Rezoning Transportation Analysis

Petition Number: 2025-056

From: Jake Carpenter, PE

Date	Description
6-25-25	First Review (CM)
7-24-25	Second Review (CM)
8-26-25	Third Review (CM)

**SCHEMATIC
SITE PLAN**

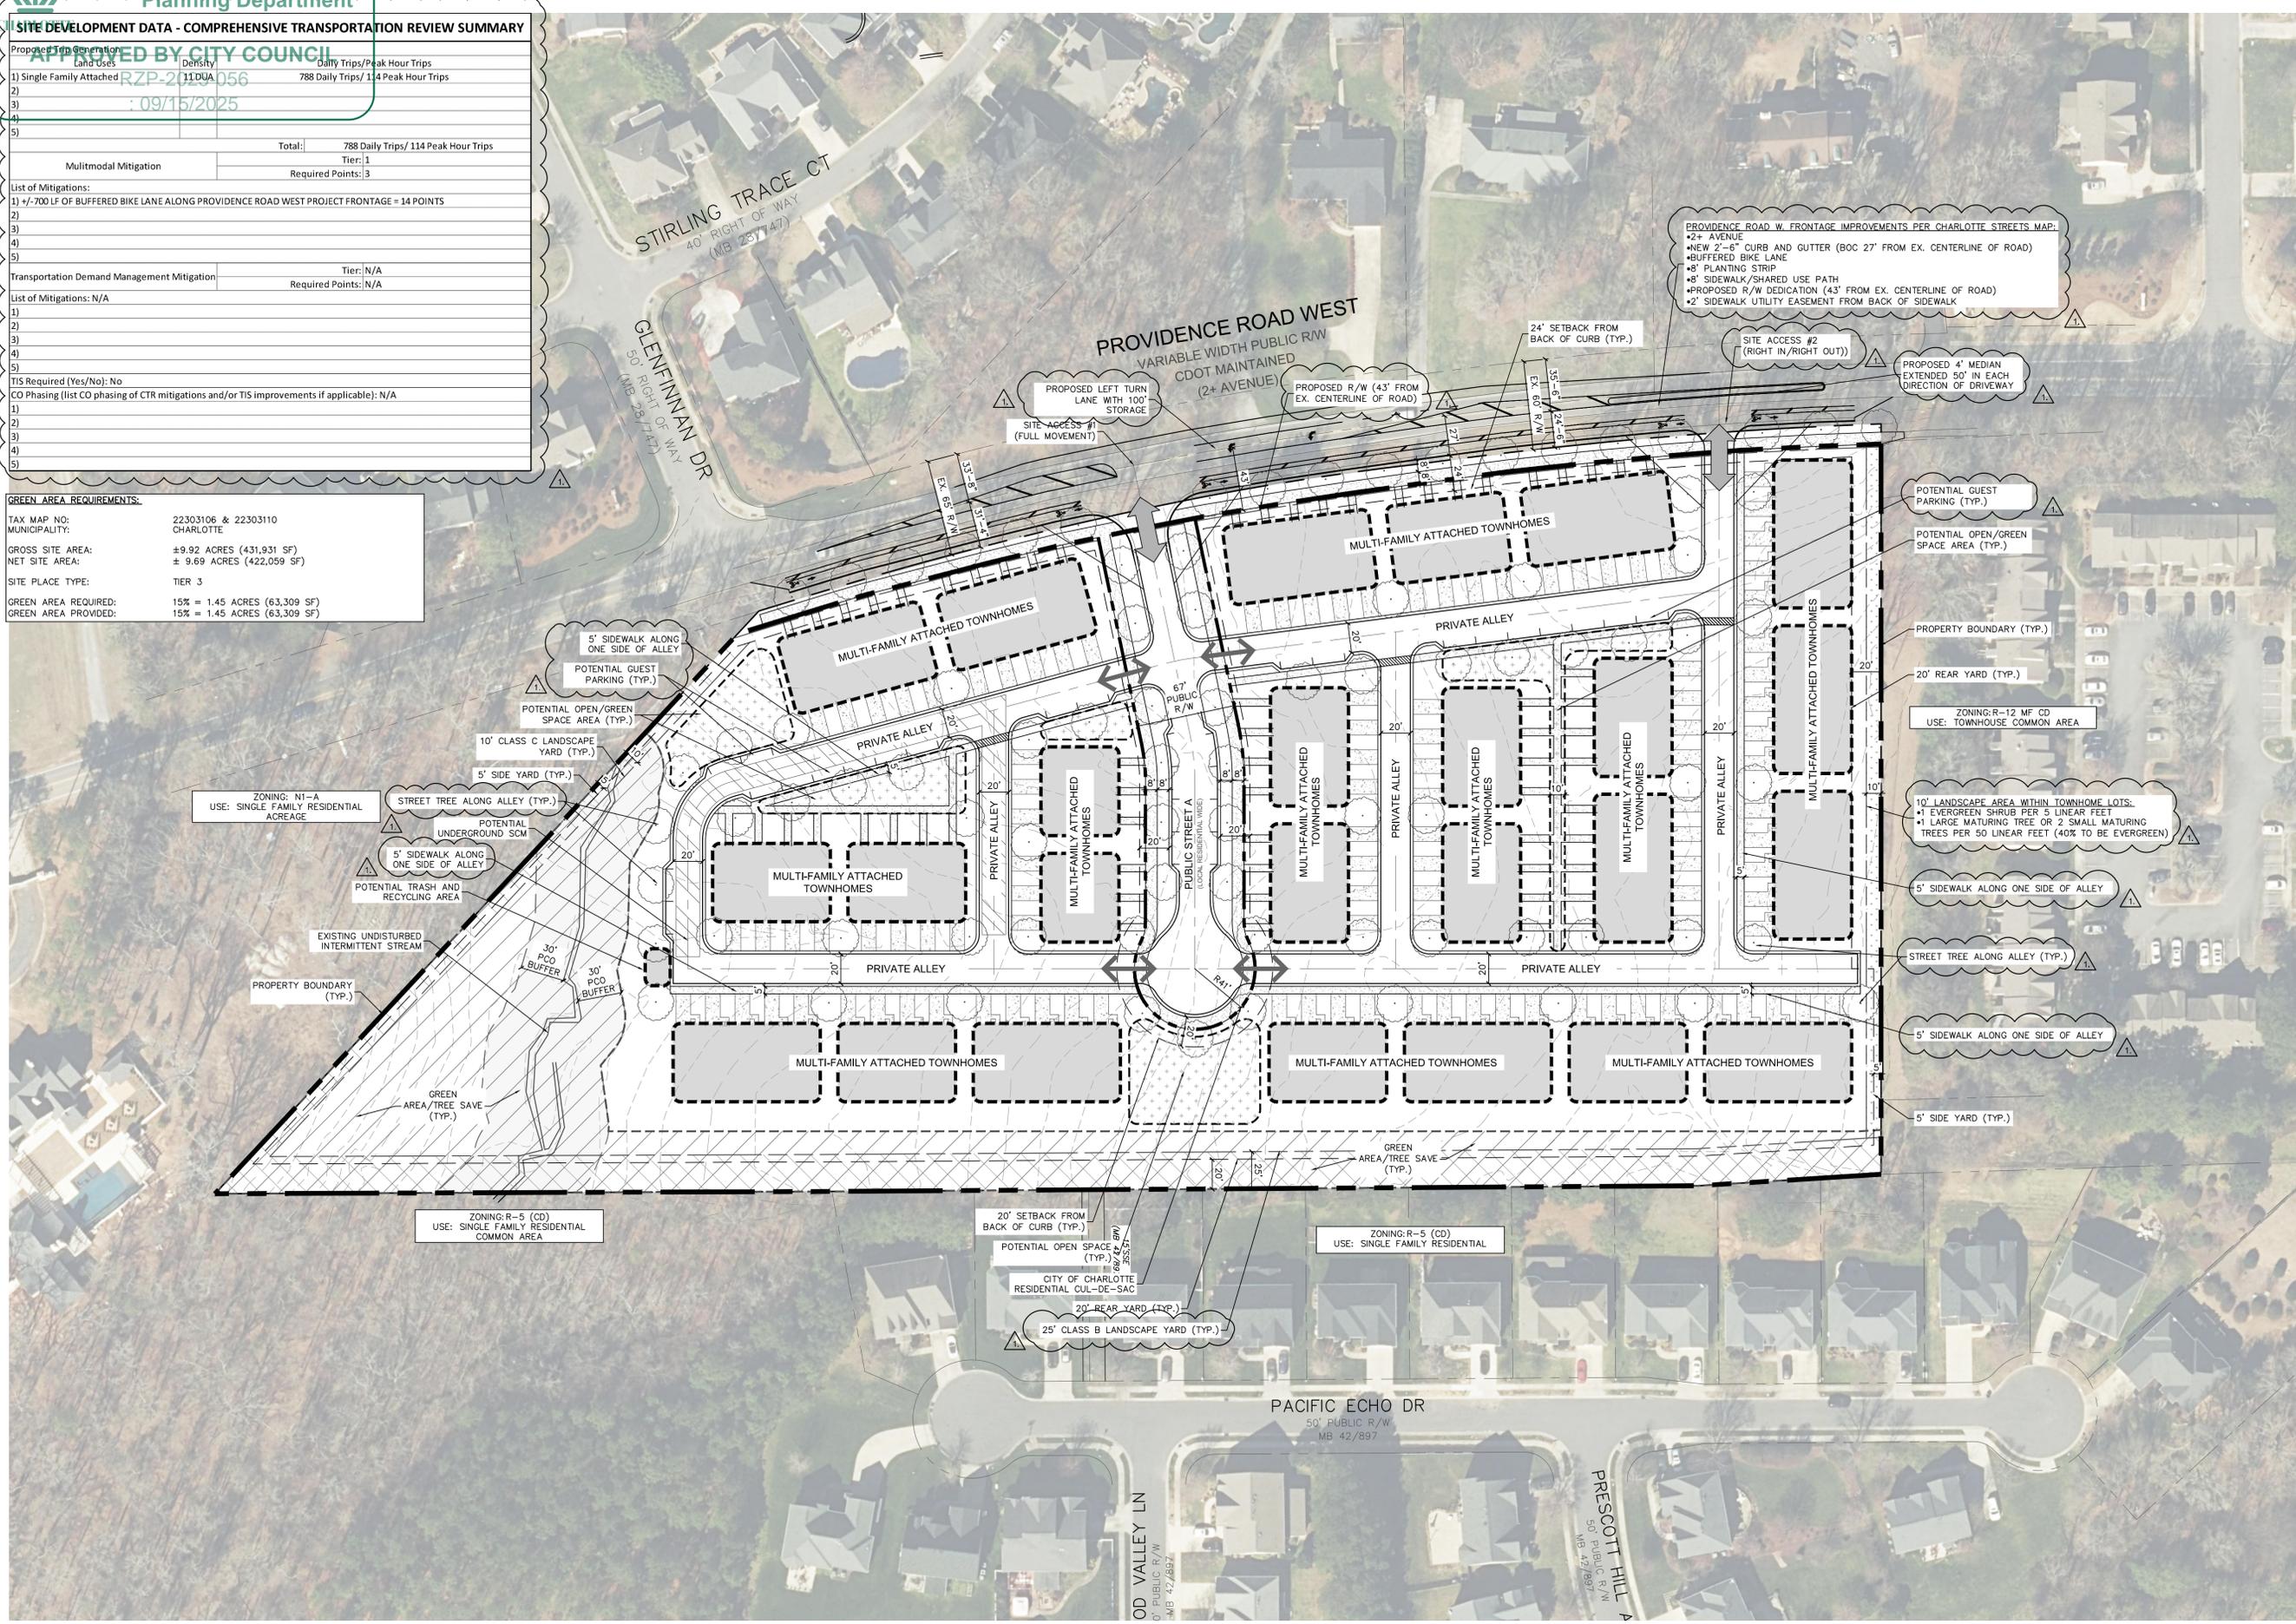
- a. ~~Providence Road West : Location of future curb and gutter is 27' from road centerline. Curb and gutter will need to be constructed in this location.~~

~~Label and dimension the curb and gutter from the centerline for each road on the site plan.~~

3. ~~Revise site plan and conditional note(s) to commit to dedicate 43' right-of-way from the road centerline. The site plan shall label and dimension the right-of-way from the road centerline.~~
4. ~~Revise site plan and conditional note(s) to commit to construct bicycle facilities by locating the curb and gutter 27' from the center line in accordance with the council-adopted Charlotte Streets Map. Multi-use paths maintained by the City shall meet ADA/PROWAG requirements.~~
5. ~~Revise site plan and conditional note(s) to show Site Access #2 as Right in, Right out only with 4ft wide median extended 50ft in both directions past the driveway. Access #1 can remain full movement. Widen~~

~~Providence Road West to provide a left turn lane with a minimum of 100' of full width storage at Access #1.~~

- ~~6. Revise site plan to show road Providence Road West centerline at centerline of roadway. It may just be an offset aerial that is causing the roadway centerline to appear on the north side of the double yellow.~~
